Address: 16965 Lindbergh Road, Monument, CO 80132

Use(s):
 Church / religious institution

County File No. PPR2048

DRAWN BY: O.E. WATTS DATE: DWG. NO.: SURVEYED BY: DEV, ESW, 4-29-20	APPROVED BY: PROJ. NO.: DWG. NO.:	REVISIONS	OLIVER E. WATTS CONSULTING ENGINEER COLORADO SPRINGS	PROJECT 16965 LINDBERGH ROAD N1/2, N1/2, NW1/4, SE1/4, SEC. 22, T.11S., R.67W. EL PASO COUNTY	SHIT. NAME SITE DEVELOPMENT PLAN	SHIT. NO. 1 OF
--	---	-----------	--	--	--	----------------------

Figure 2  
**Site Plan**

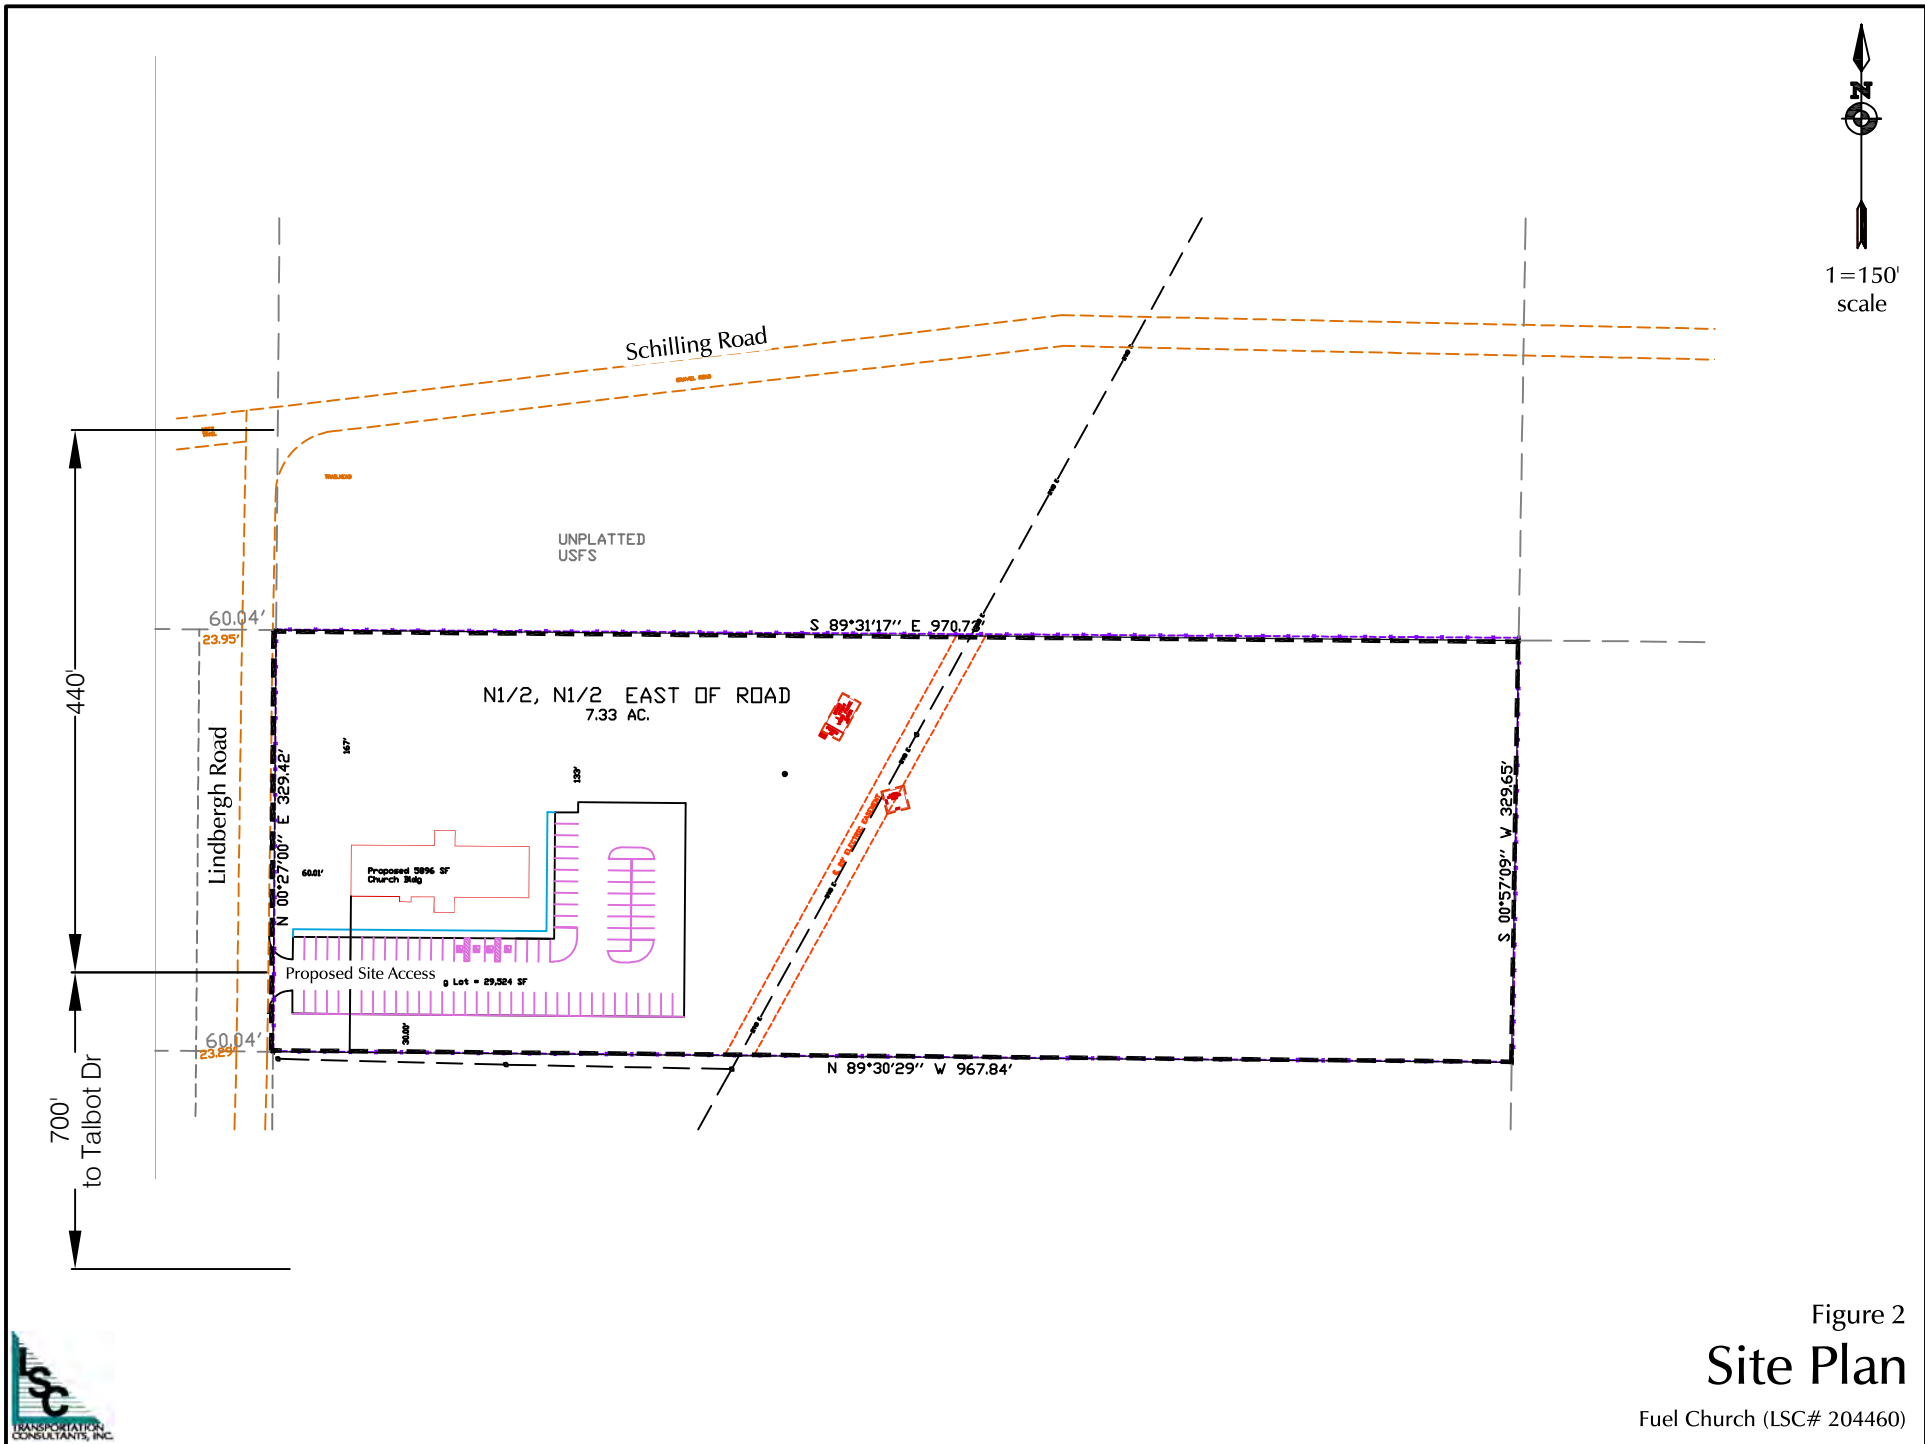
please add Lot area coverage calculation

Please add bicycle parking. Per Chapter 6 LDC parking standards: "the minimum number of bicycle parking spaces shall equal 5% of the number of required parking spaces. At least one bicycle parking shall be provided."

Please show and callout an ada route from ada parking spaces to building entrance(s)

please add symbology to legend

please show setback distances from each existing and proposed structure to the property lines
